AEA-2105-P-01

**RE: Planning Consent 2022/0843/HSE– Application for Variation**

Please find the enclosed drawings accompanied by an application to vary condition 2 of the above application to enable the following changes to be made to the design:

job no 2105 dwg no P-10 rev E

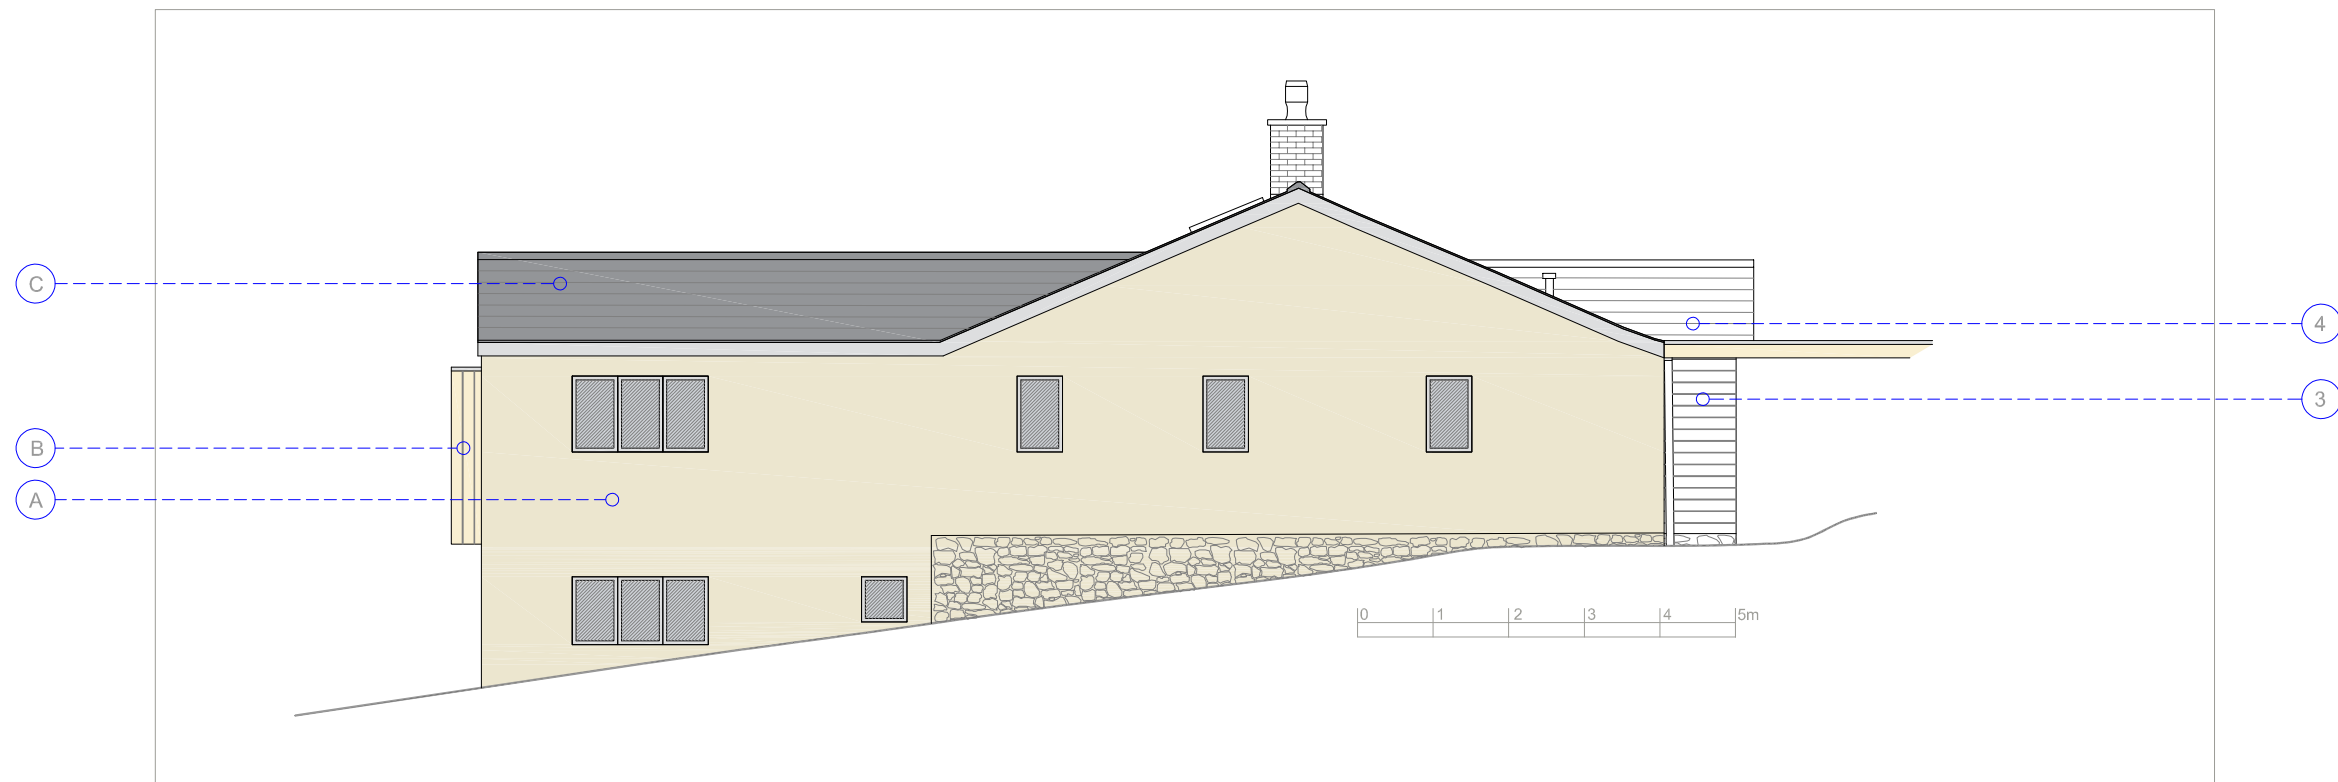
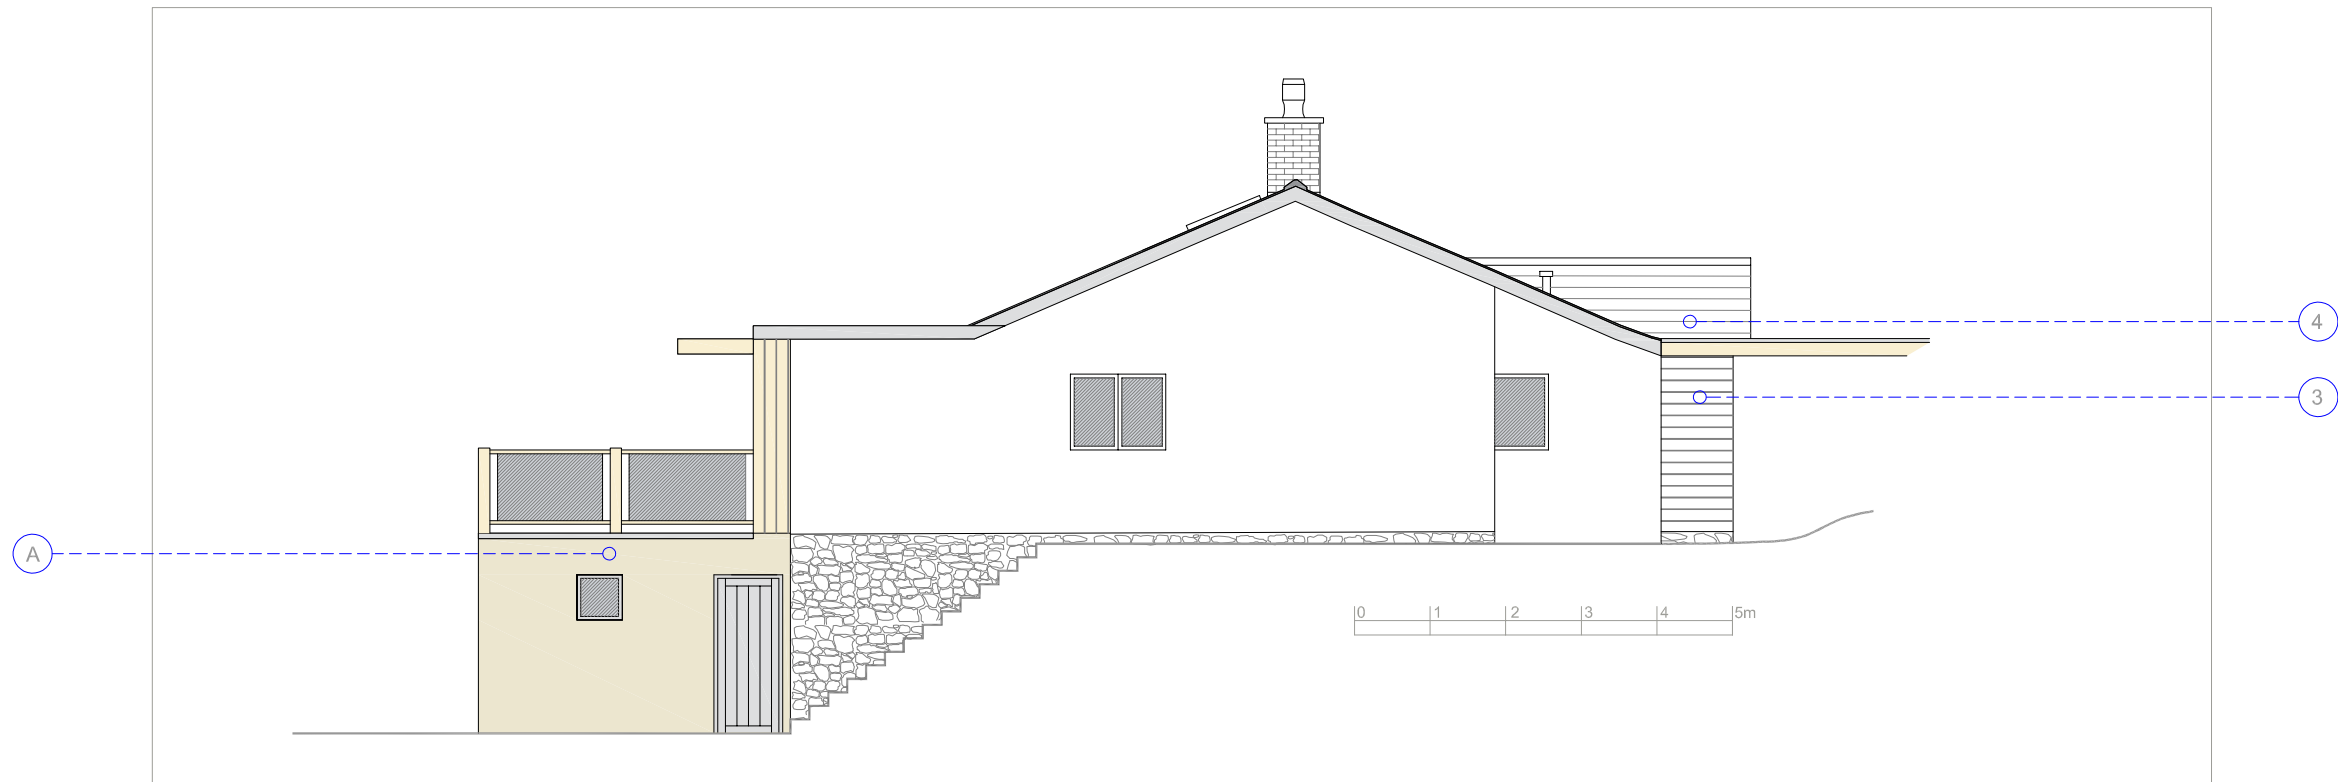
- Retention and modification of existing side extension in place of proposed replacement, resulting in reduced forward and rearward projection and decreased roof volume.
- Alterations to proposed lower ground floor layout and design, including addition of side access door.

AEA-2105-P-10 rev **E** *replaced by* AEA-2105-P-10 rev **F**

job no 2105 dwg no P-11 rev C

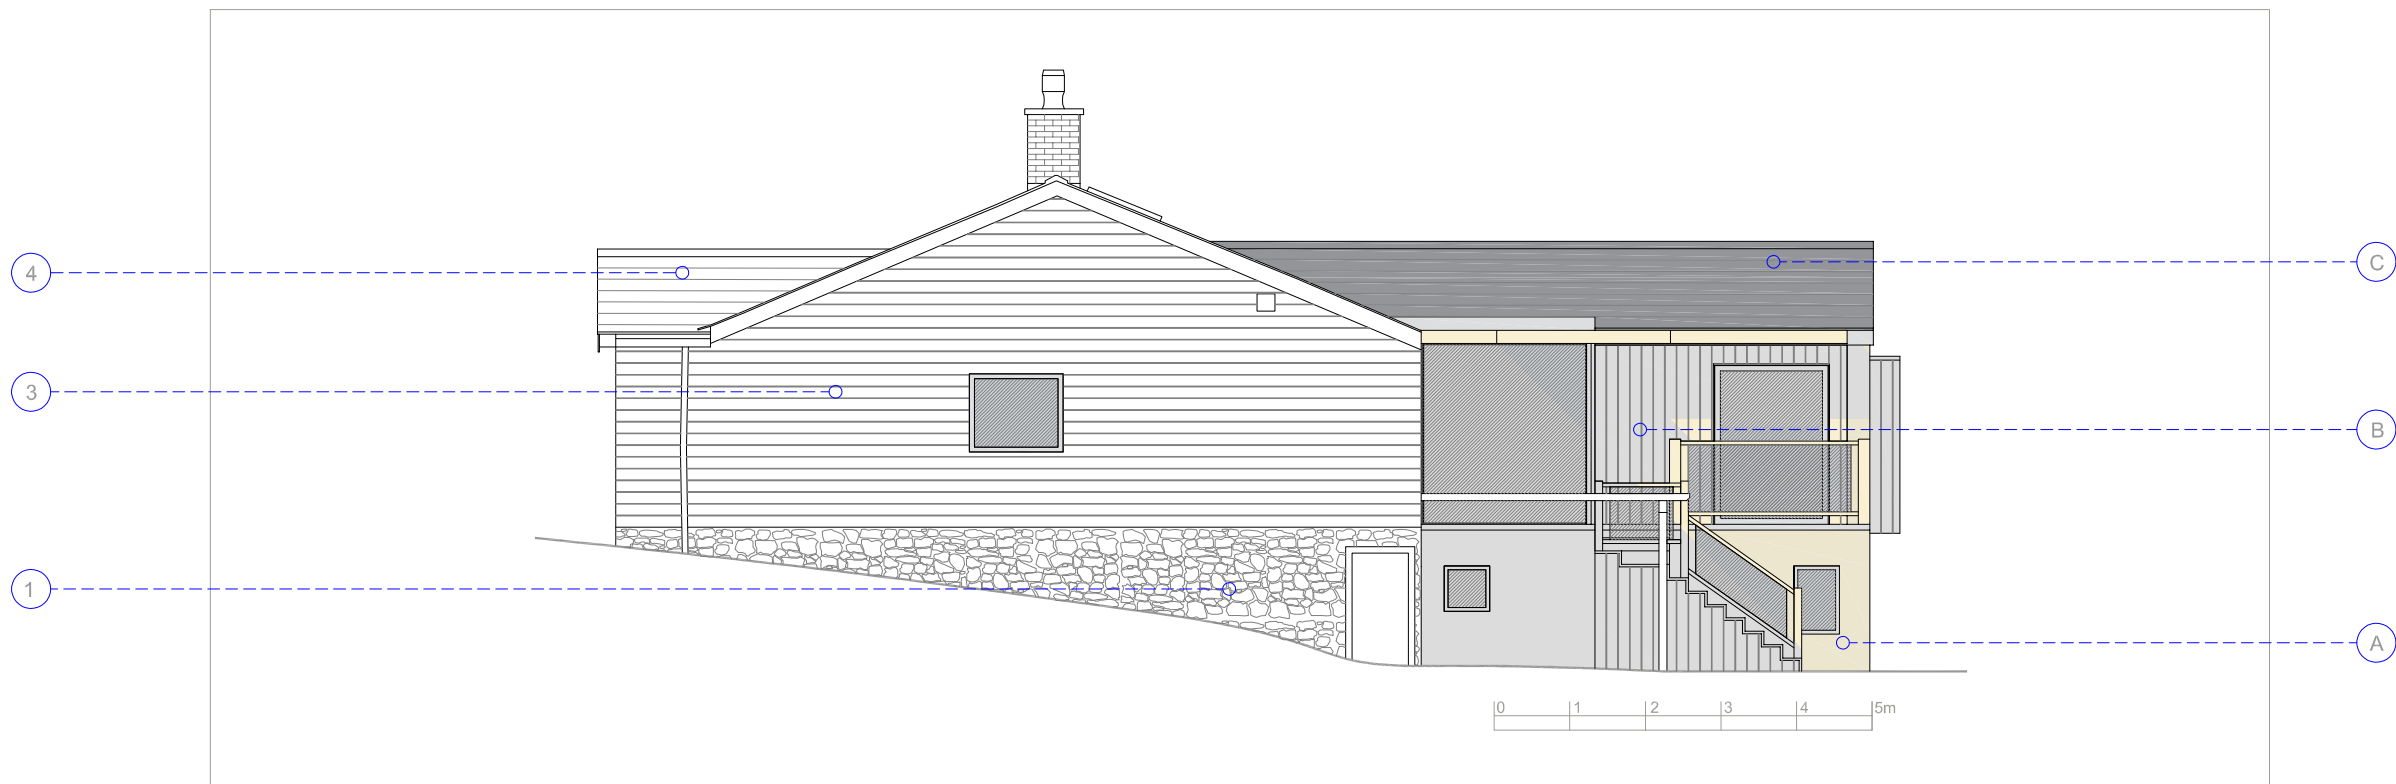
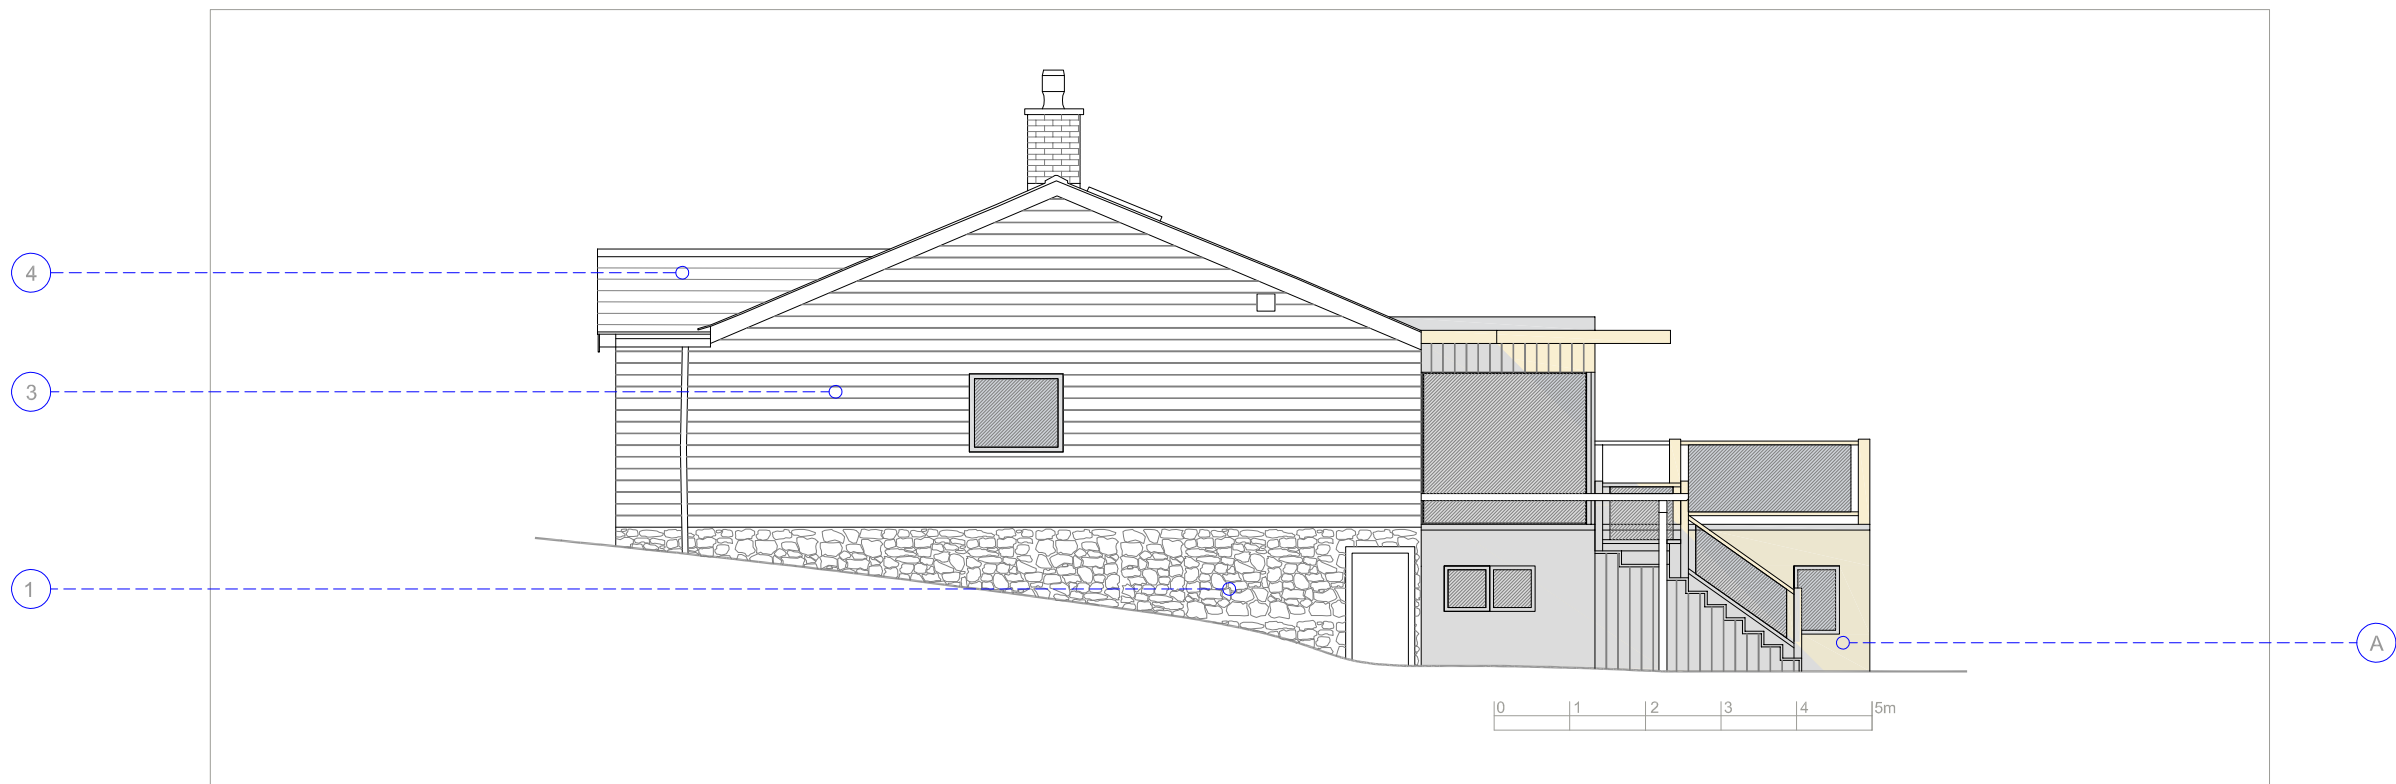
AEA-2105-P-11 rev **C** *replaced by* AEA-2105-P-11 rev **D**
